GEC V_1.pdf Markup Summary

SP-19-003

EC03

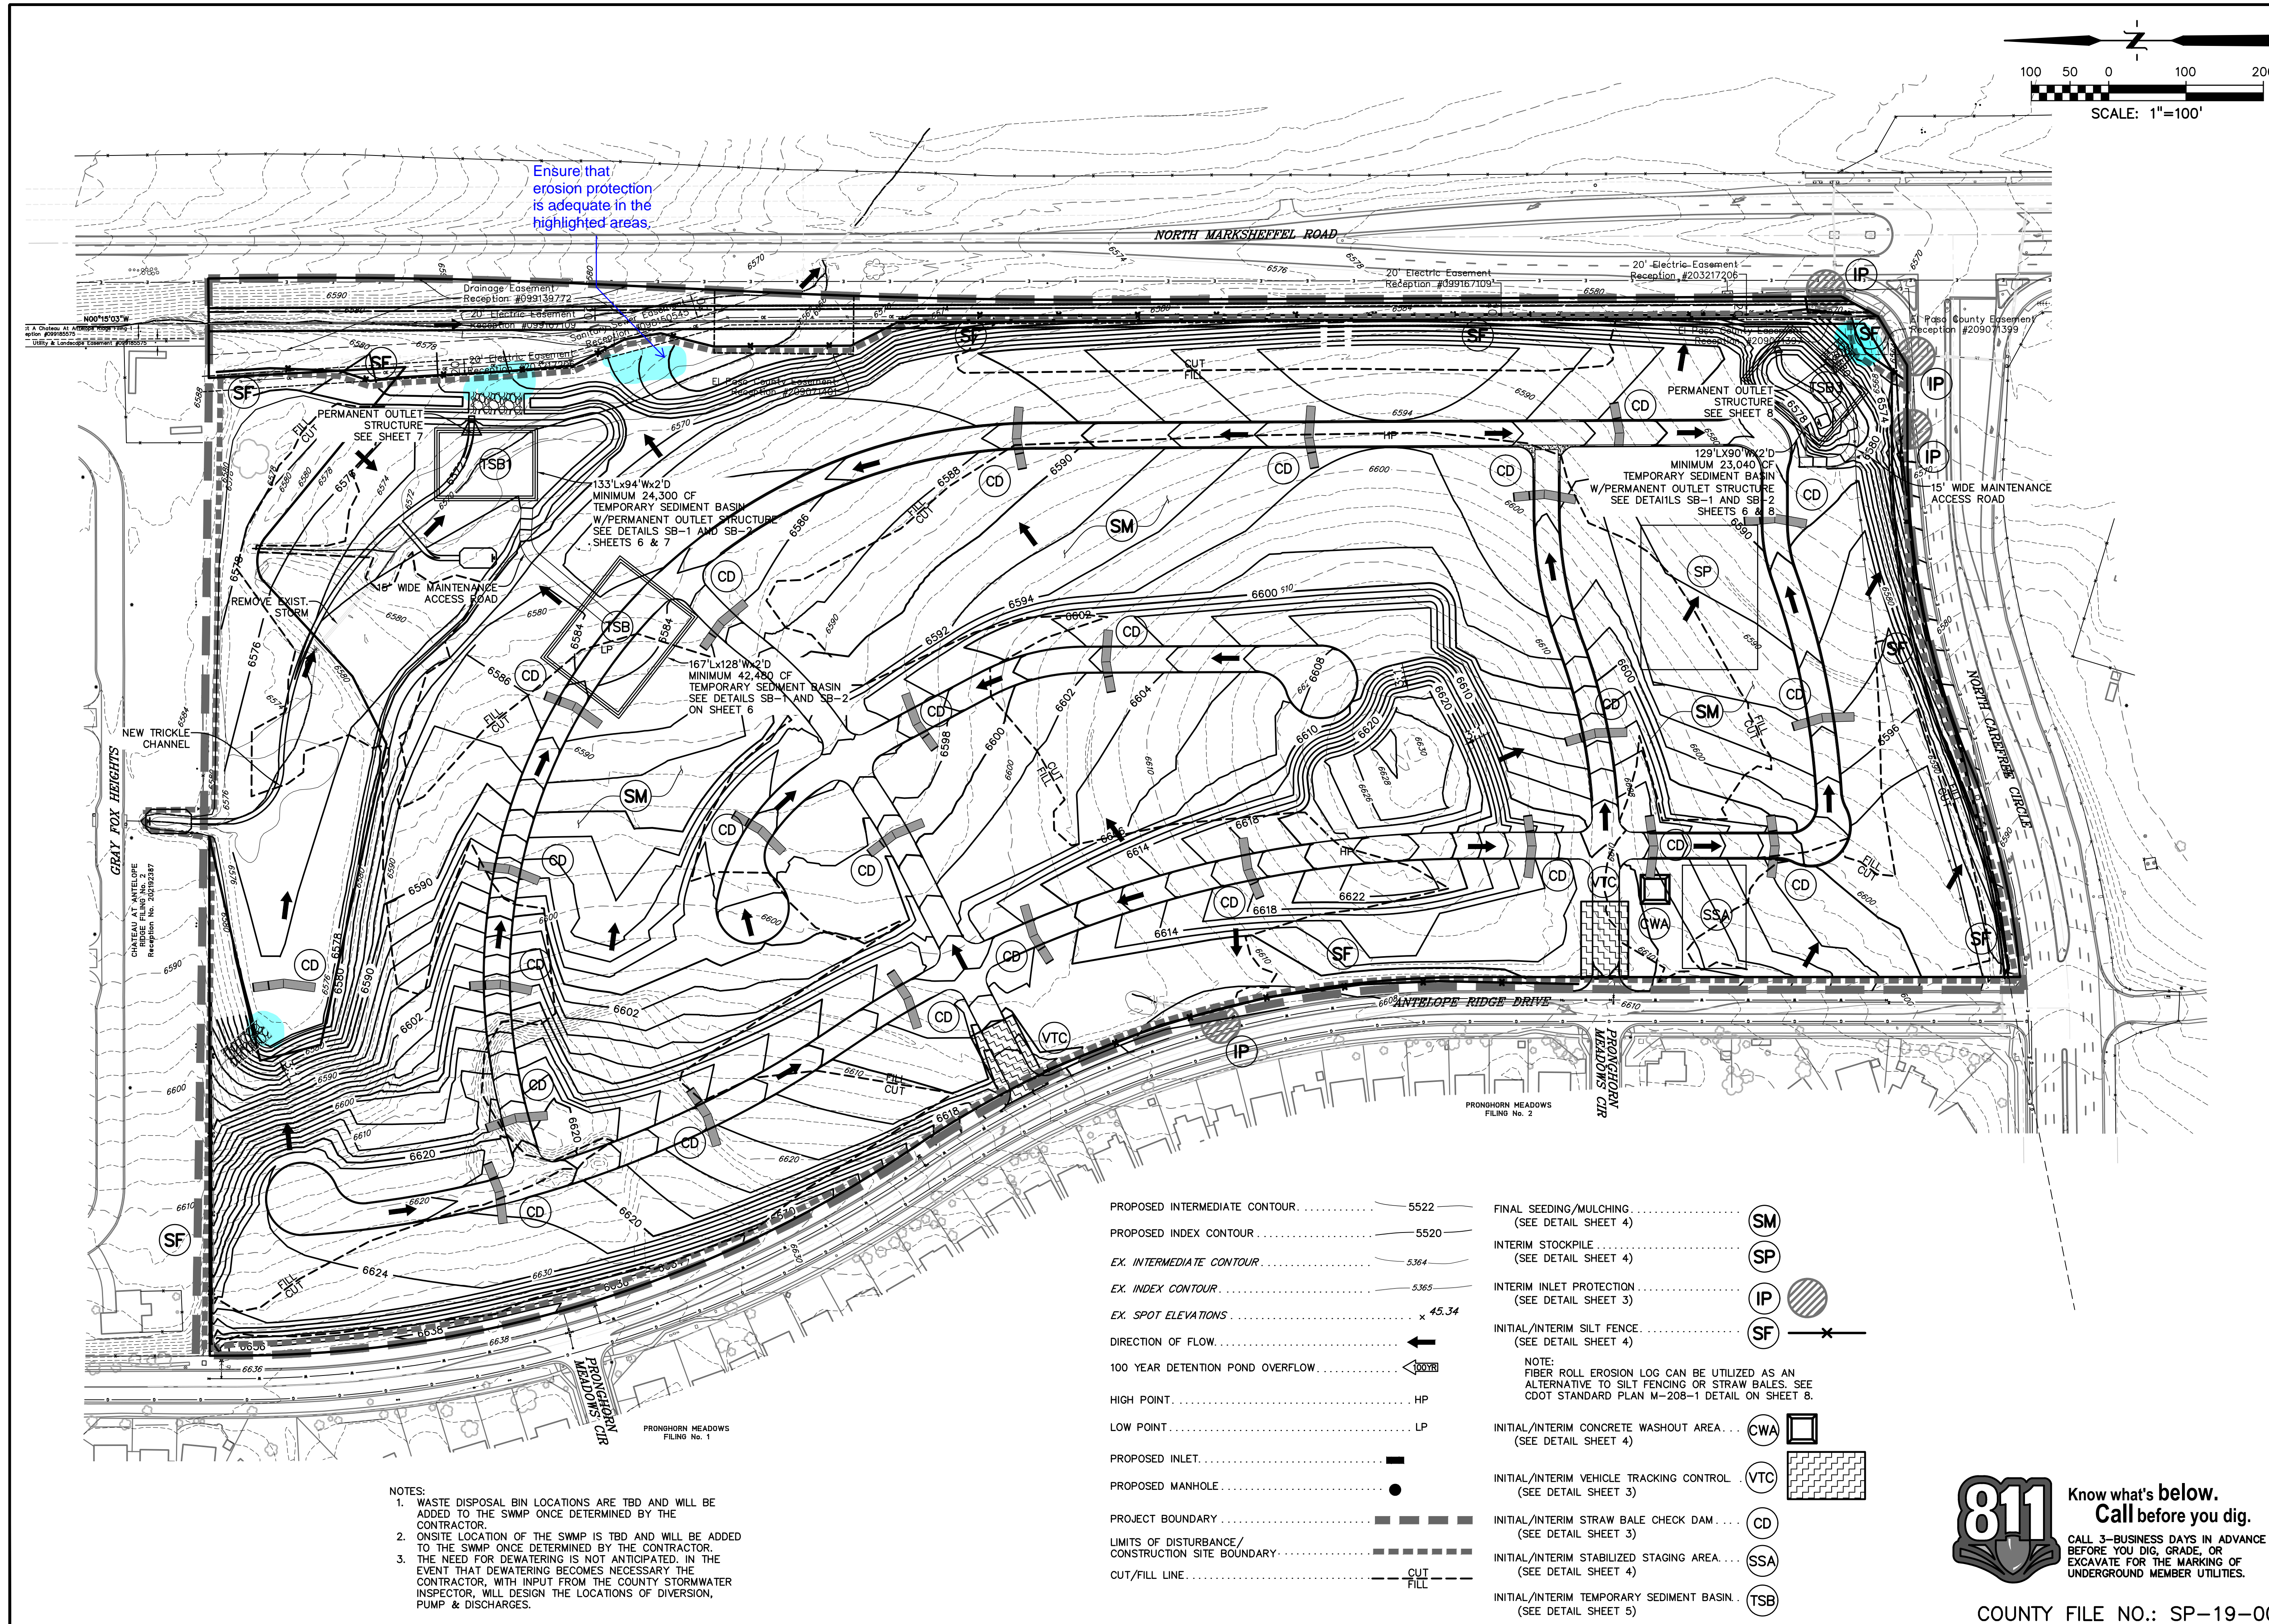
75

EC02

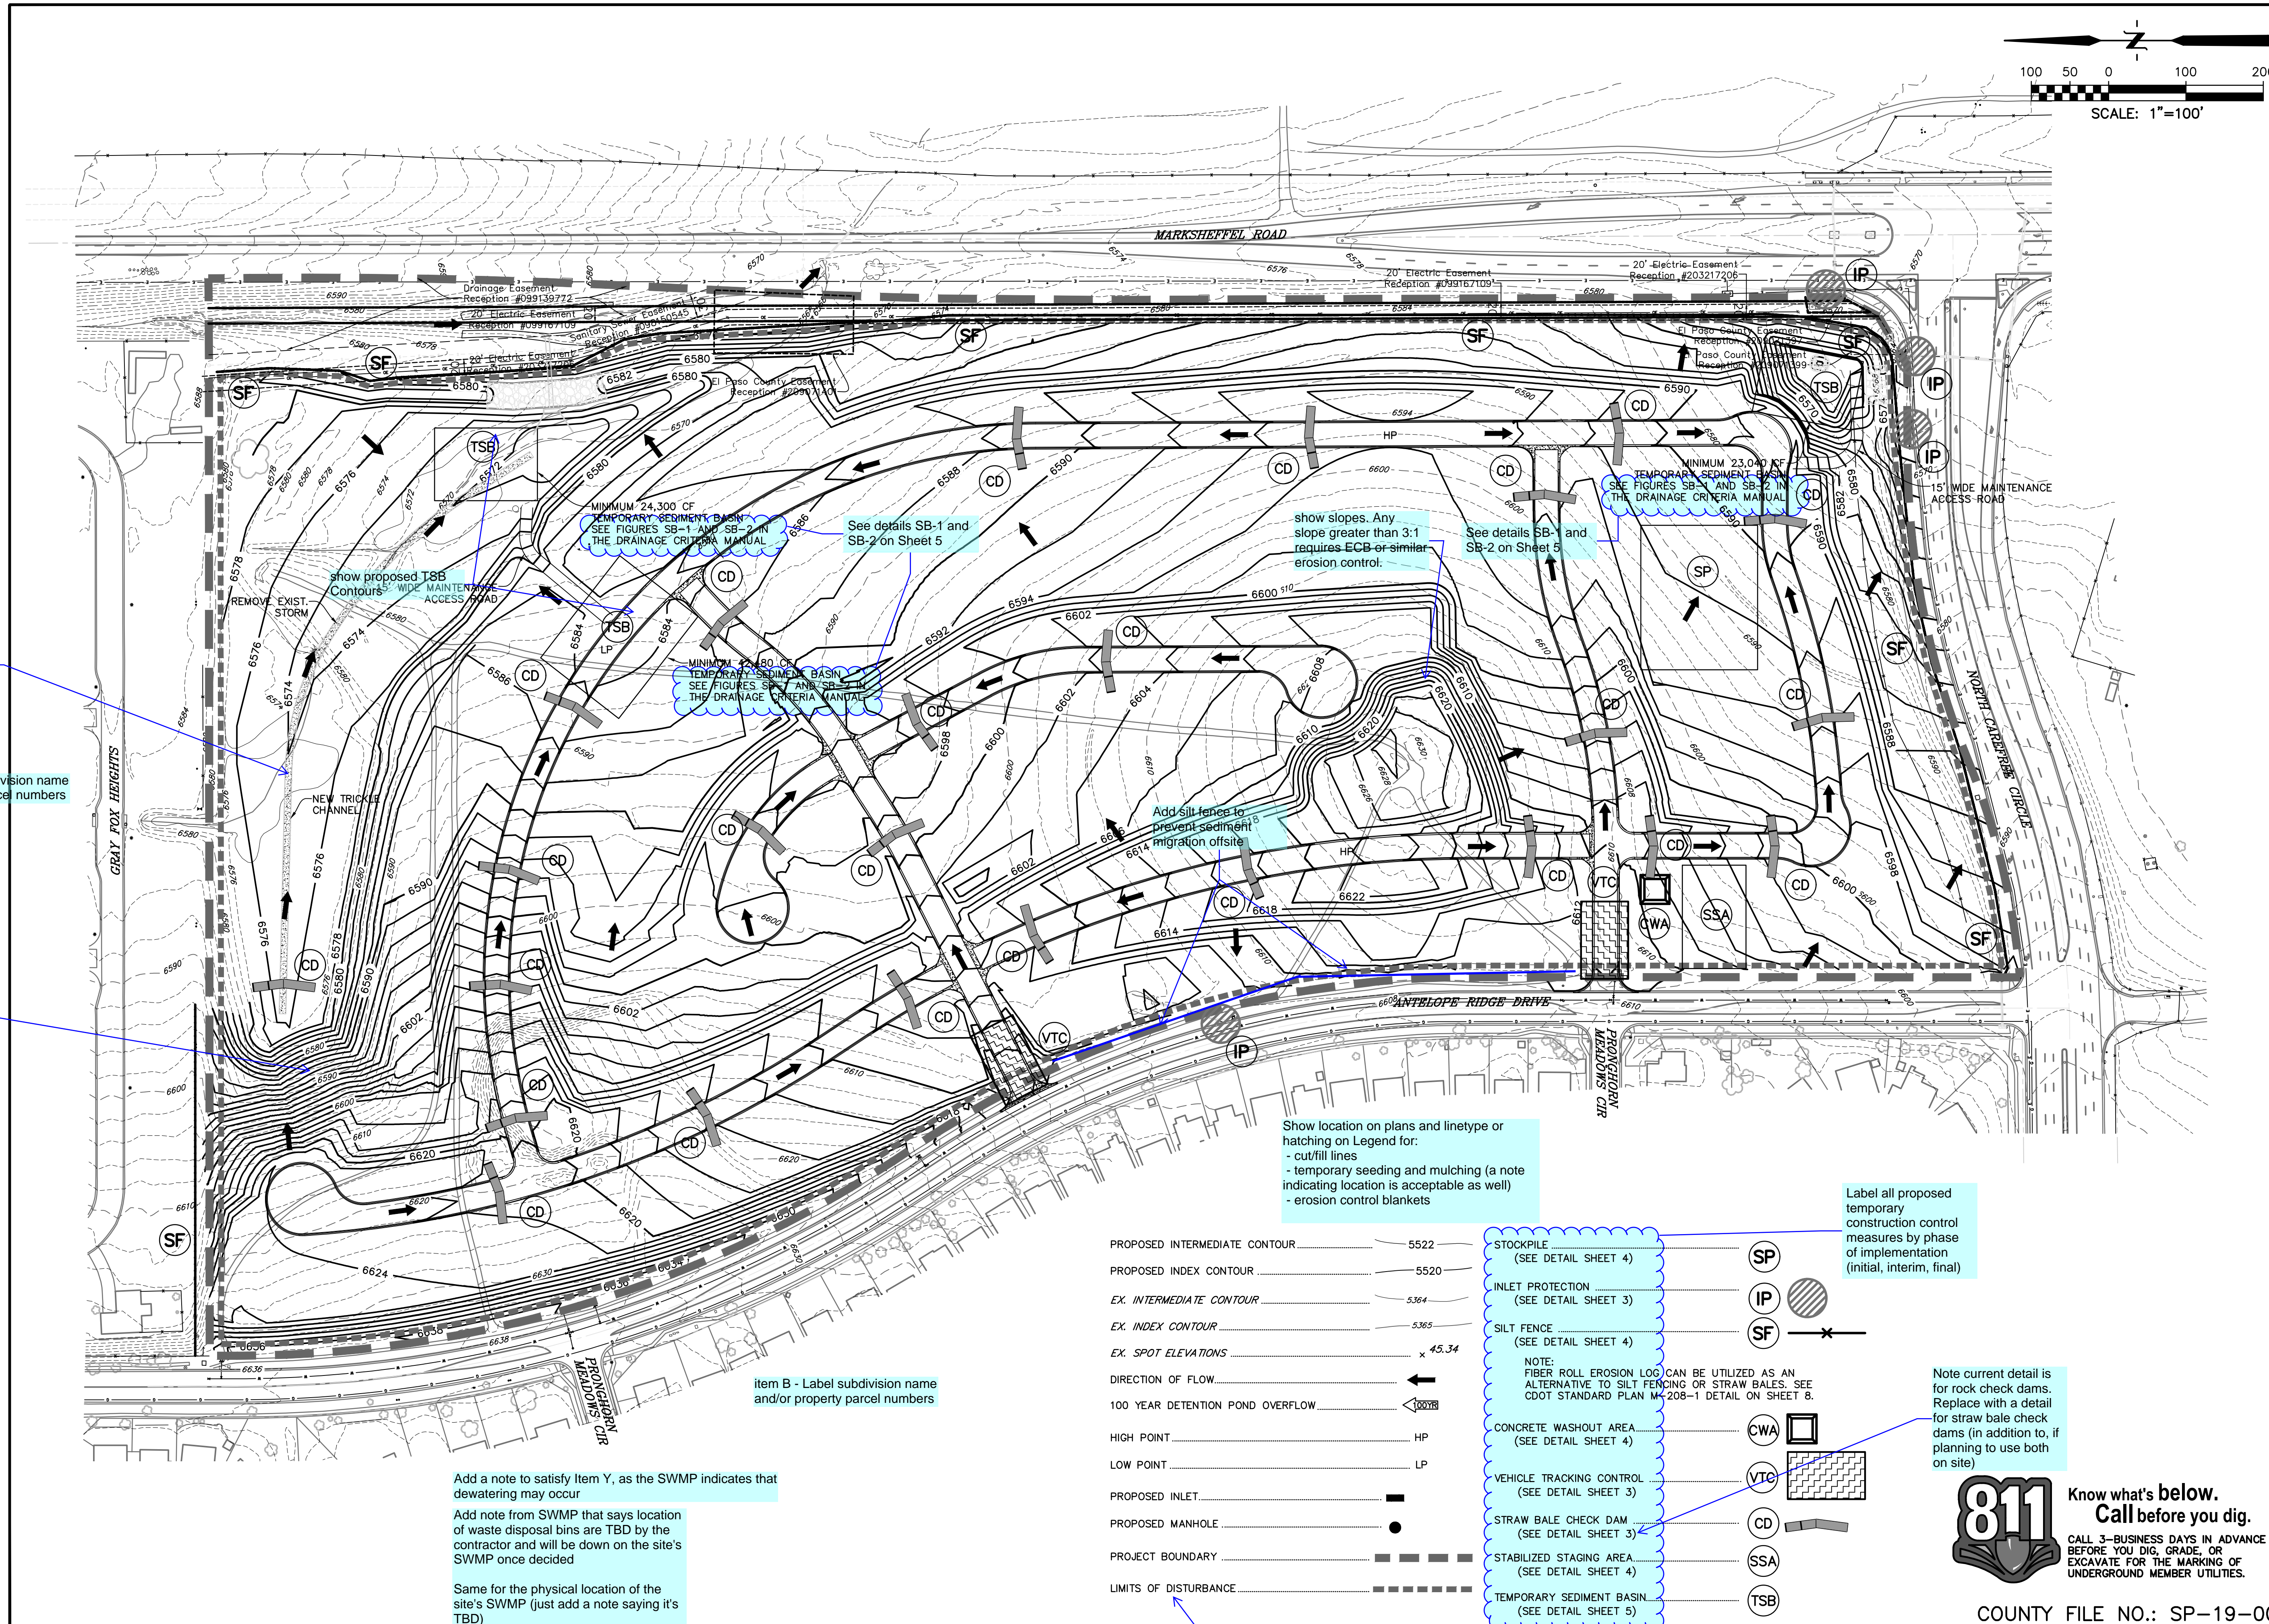
no construction access from Marksheffel

Use a "hidden" or dashed linetype for existing contours.

Show spillway erosion protection.

Label all features being constructed and removed.
